**NSW Department of Planning and
Infrastructure**

**GUJARAT NRE NO.1 COLLIERY MAJOR
EXPANSION PROJECT PART 3A
APPLICATION**

Preferred Project Groundwater Assessment

26 November 2013

Figure 1. Comparison of previous and current mine plans for Wonga East. Current mine plan sourced from Gujarat (2013) and overlaid with georeferenced information from Coffey (2013). Comparison of Panel Layouts for Wonga East.

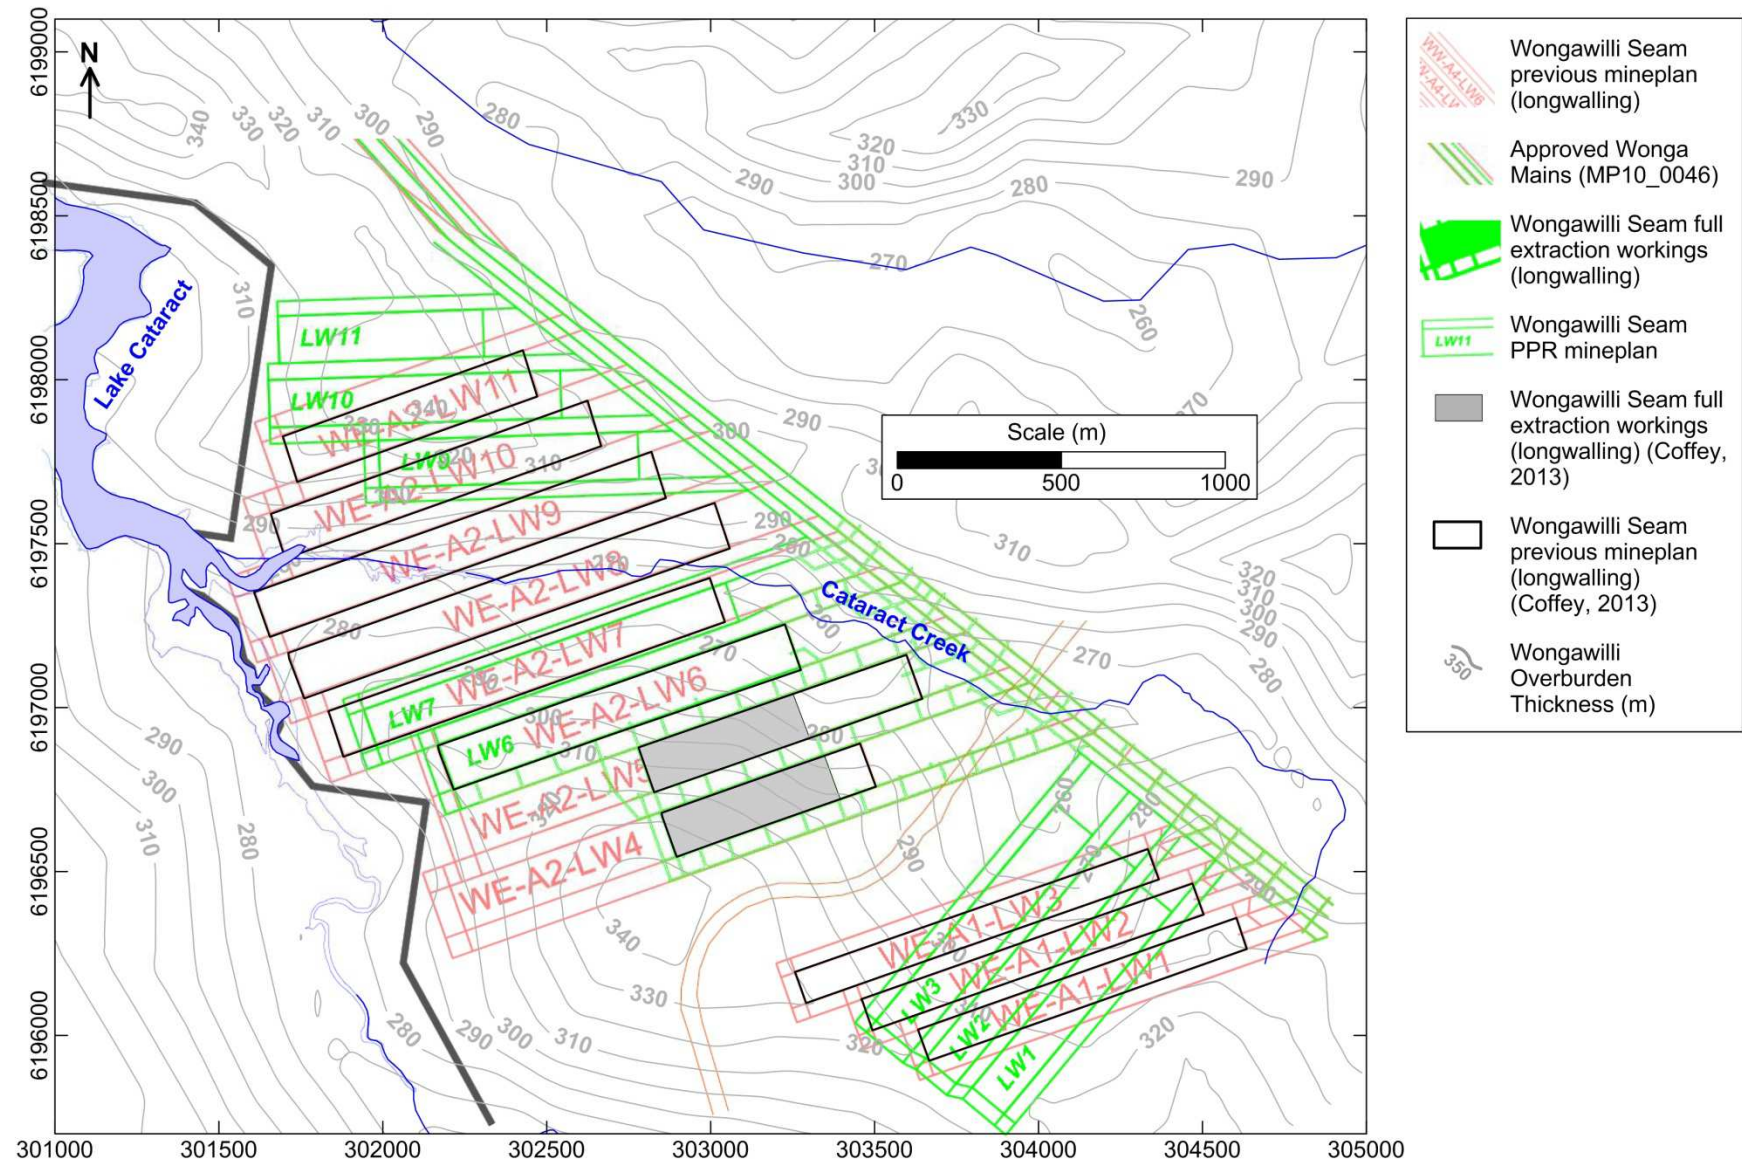
The new mine plan is presented in Figure 4 of the PPR however no scale is shown and it is not georeferenced. This mine plan was positioned with respect to the MGA by overlaying the EA and PPR mine plans of Figure 4 of the PPR onto a georeferenced drawing of the EA mine plan, and scaling it until a visual match was obtained between the two versions of the EA mine plan. The result is shown in Figure 1. This process allowed positioning of Cataract Creek (not shown in Figure 4 of the PPR) with respect to LW7 of the PPR mine plan. However, the positioning error from this process is unknown.

The new layout of LW7 (Figure 1) is still considered to pose a risk to the capacity of the channel of Cataract Creek to transmit surface water. A significant element of the risk is demonstrated by the indication provided by subsidence monitoring of Balgownie and Wongawilli Seam panels in Wonga East as discussed in the PPR. Incremental Balgownie panel subsidence ranged between 0.9m and 1.2m where overlying Bulli goaf (room and pillar panels with pillar extraction) was present, approaching 80% of the mined height (implying a mined height of about 1.5m for the Balgownie panels). In unusual areas (latent subsidence, goaf edge), the incremental subsidence reached 1.4m, approaching 100% of the mined height. Figure 2a (after Figure 49 of the PPR) shows these results.

Figure 4. New proposed position of Wongawilli LW7 as per the PPR.

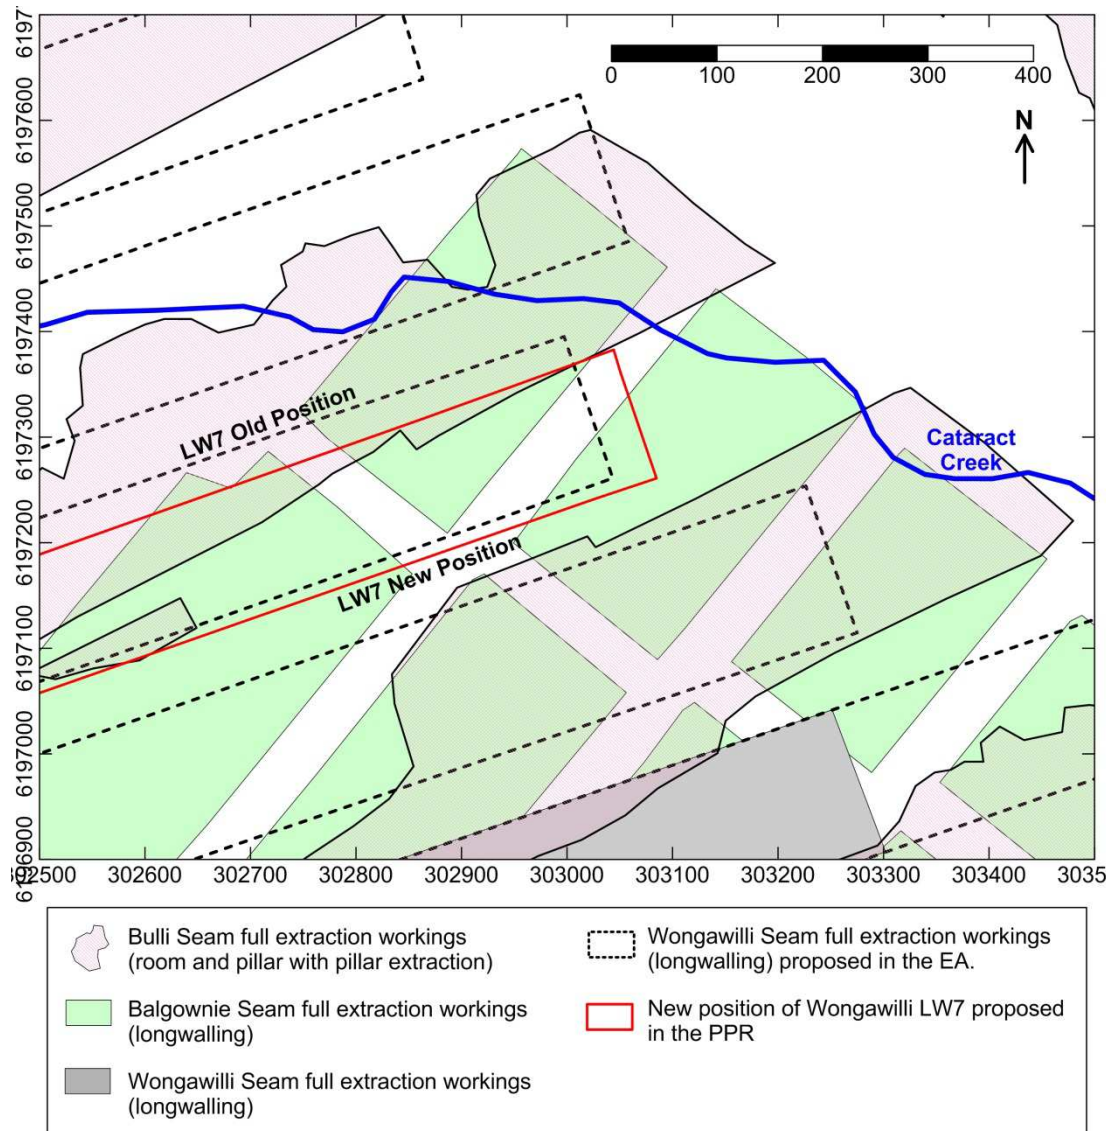
The overburden thickness at the northern corner of LW7 is approximately 260m, so that the creek channel falls within interpreted zones of impacts to hydraulic heads from longwall mining. Using 45° as an upper limit, the angle of influence would extend surface impacts to a distance of about 260m from the boundary of LW7 in the vicinity of its northern corner. This estimate does not include the effects of multiple mined seams, nor the effects of topographic gradients, both of which may alter the zone of influence.

Where the top of a collapsed zone is some distance below the surface, the surface disturbance at a channel bed may not be strongly hydraulically linked to the collapsed zone. In the case of LW7, there is considered to be a risk of direct hydraulic connection between the creek channel and goaf, through the collapsed zone, where the channel comes close to the panel edge. The level of risk is difficult

to quantify but warrants consideration. Monitoring of groundwater response and ground deformation in this area during the early stages of LW7 retreat may be useful in better informing the risk.
